Subject: FW: FP/248/20/PL - revised details relevant to the sport pitch & changing facilities building Site 6 Felpham

Subject: FP/248/20/PL - revised details relevant to the sport pitch & changing facilities building Site 6 Felpham

Please find comments set out in bullet points below:

Drawing Title:
CHANGING FACILITIES BUILDING

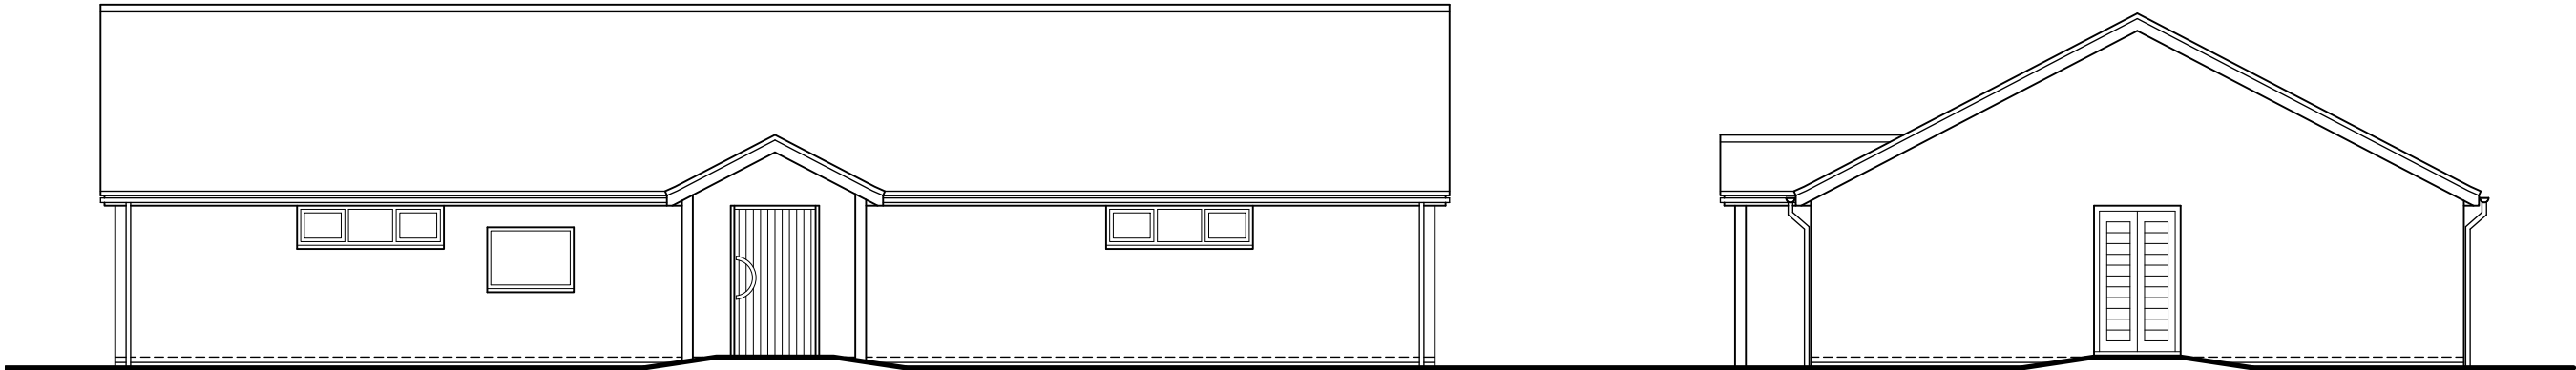
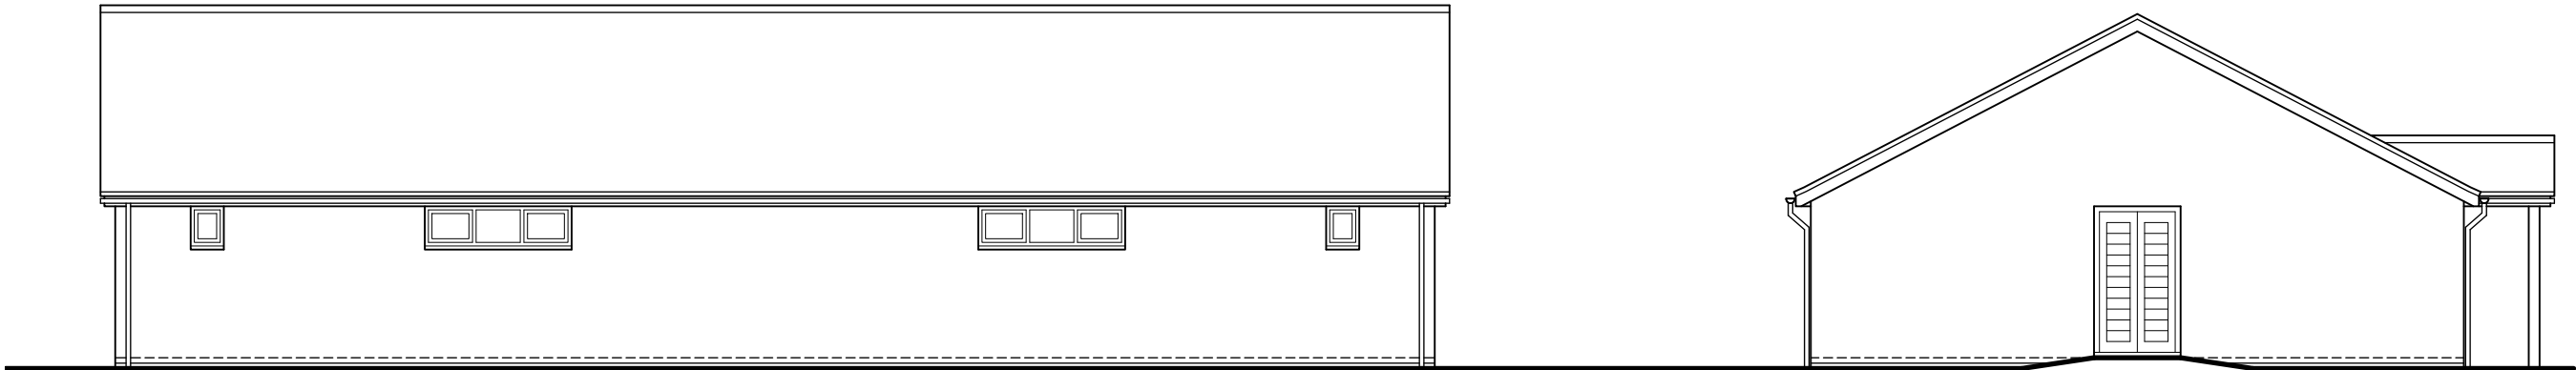
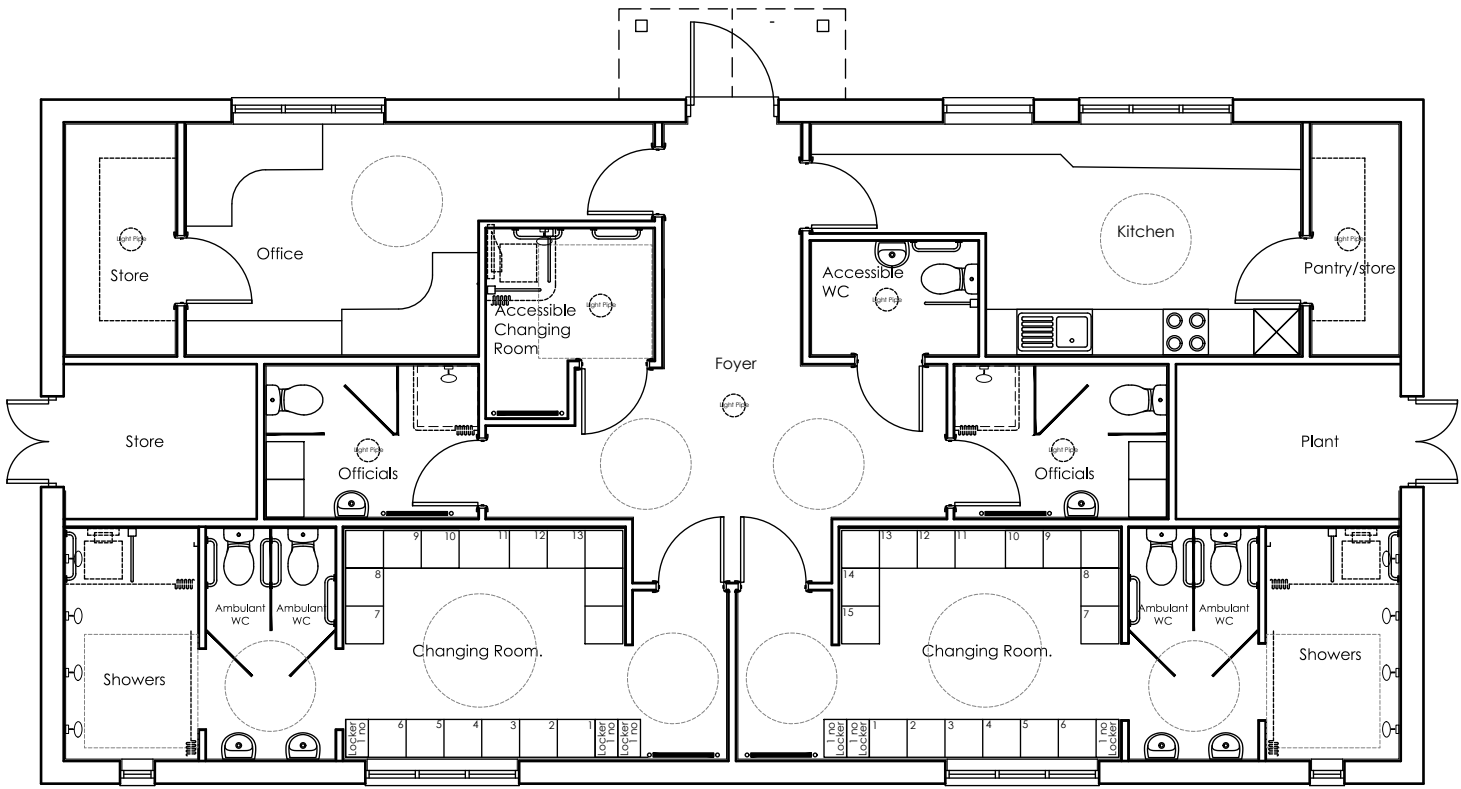
- Support the construction of a pitched roof.
- Support the use of brick external finish facing of building material.
- Each changing room is required to have 2 w/c, not one as illustrated.

- Two separate officials changing facilities are required.
- All windows to be at high level and using vandal proof materials – i.e. screened toughened glass or blacked out windows with natural light made available through roof lights / tubes.

- Use of light tubes or similar to allow natural light into central rooms of the building
- External doors will need to be of adequate security to be durable and prevent forced entry – e.g. metal face.

- Main entrance door to be outward opening.
- All drain pipes and guttering to be vandal resistant and to prevent climbing – for example internal drainage or buttress protected down pipes.

- The services arrangements including foul drainage for the facilities need to be confirmed to ensure the building is adequately served.
- The area of the building is noted. ADC would wish the changing room/facilities to be aligned with the Sport England design principles and specifications to ensure that the building is fit for purpose. This would include an area to provide opportunity for a communal room / space within the building and an external serving hatch.

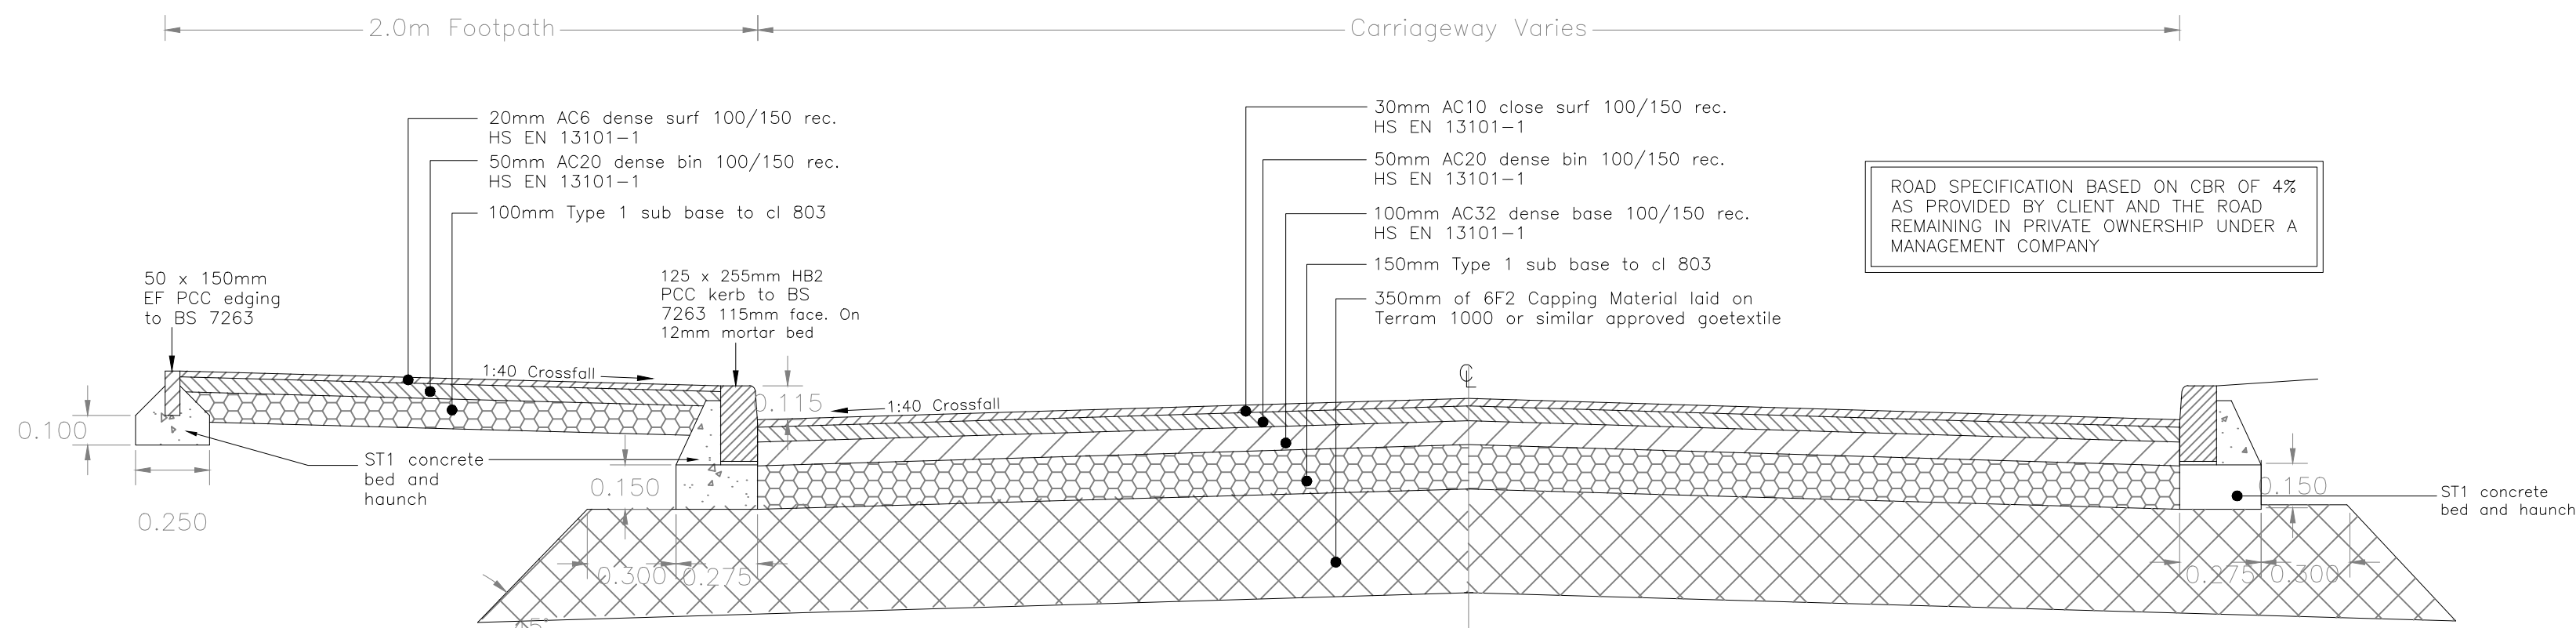
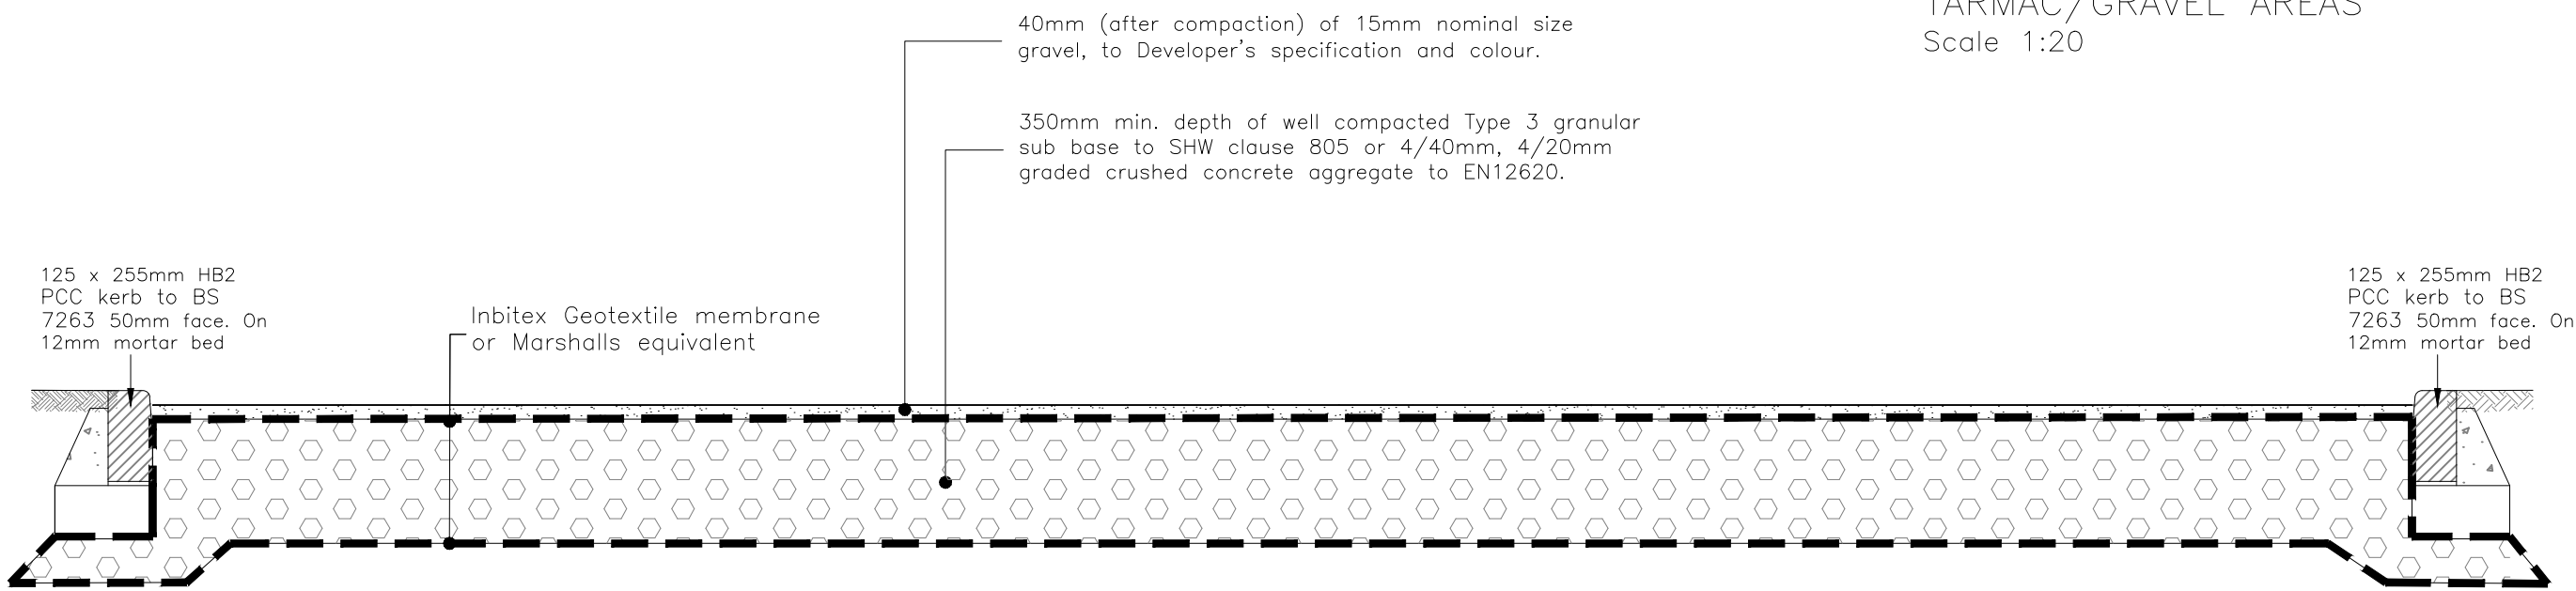
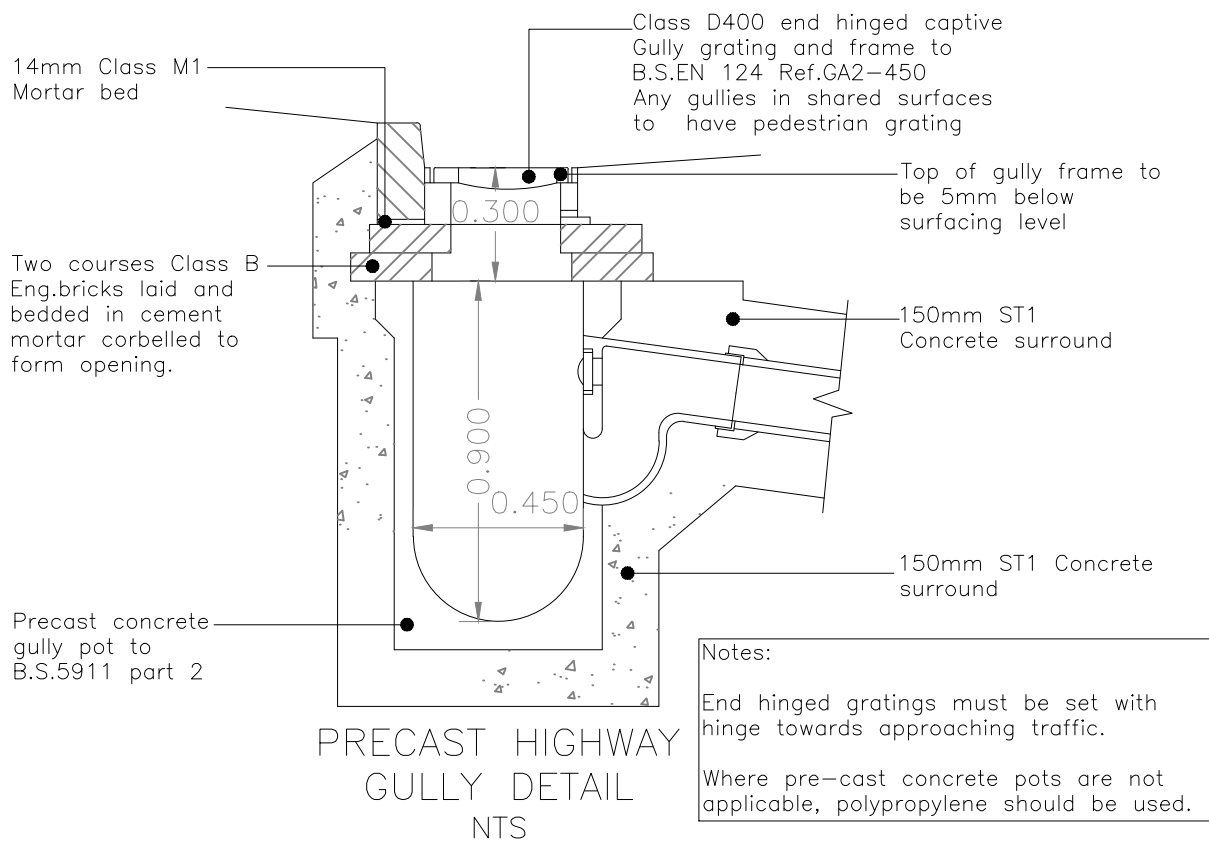
- Detail drawings to illustrate the fencing and the provision of a security gate and height barrier for approval is required.
- Specification of all tarmac surfacing, including sectional drawings and drainage must be provided for approval.

client: Barratt Homes
drawing: Hard and Soft
Landscape Proposals

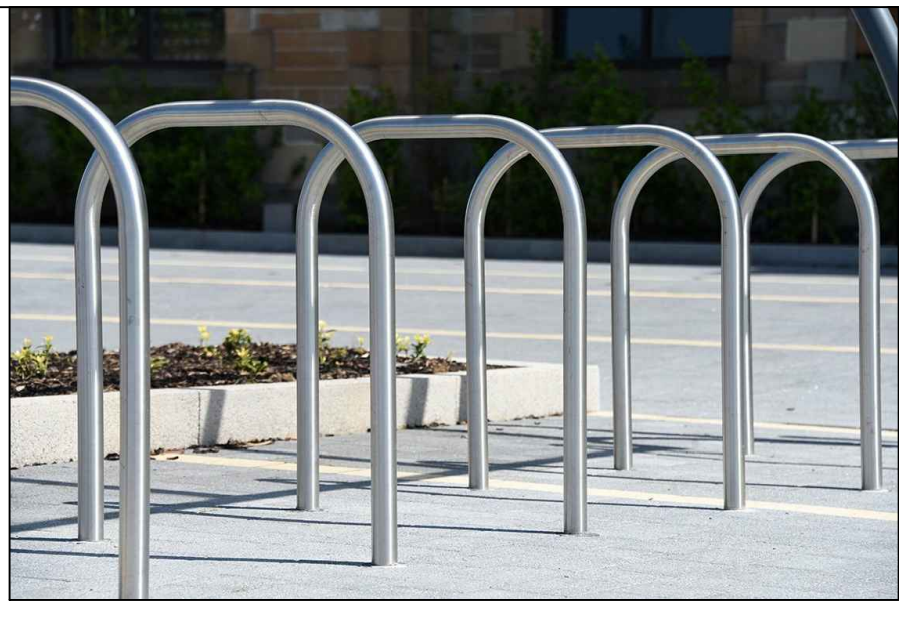
- There is no reference to the boundary fencing detail for large parts of the site – this must be provided. The site boundary must be clearly established on the ground in all areas.

- Provision of site furniture such as seating, bins and dog bins to be provided on site – detail and locations to be approved.

- Drawing needs to identify existing native planting to relief road boundary – on the noise bund and either side of the acoustic fencing.
- Details of tree / hedge planting is required – further planting opportunities should be demonstrated, particularly on site boundaries – species is not identified – this must be provided for approval.
- Section drawings information and their location in relation to the site and finished levels needs clarification – this to include the access road / car park area - all required for approval. Attention needs to be given to ensure levels marry in with surrounding landscape – particularly in areas where the ground is made up. Areas of ground must not be compacted; where this is evident the developer will be required to make good prior to transfer to ADC.
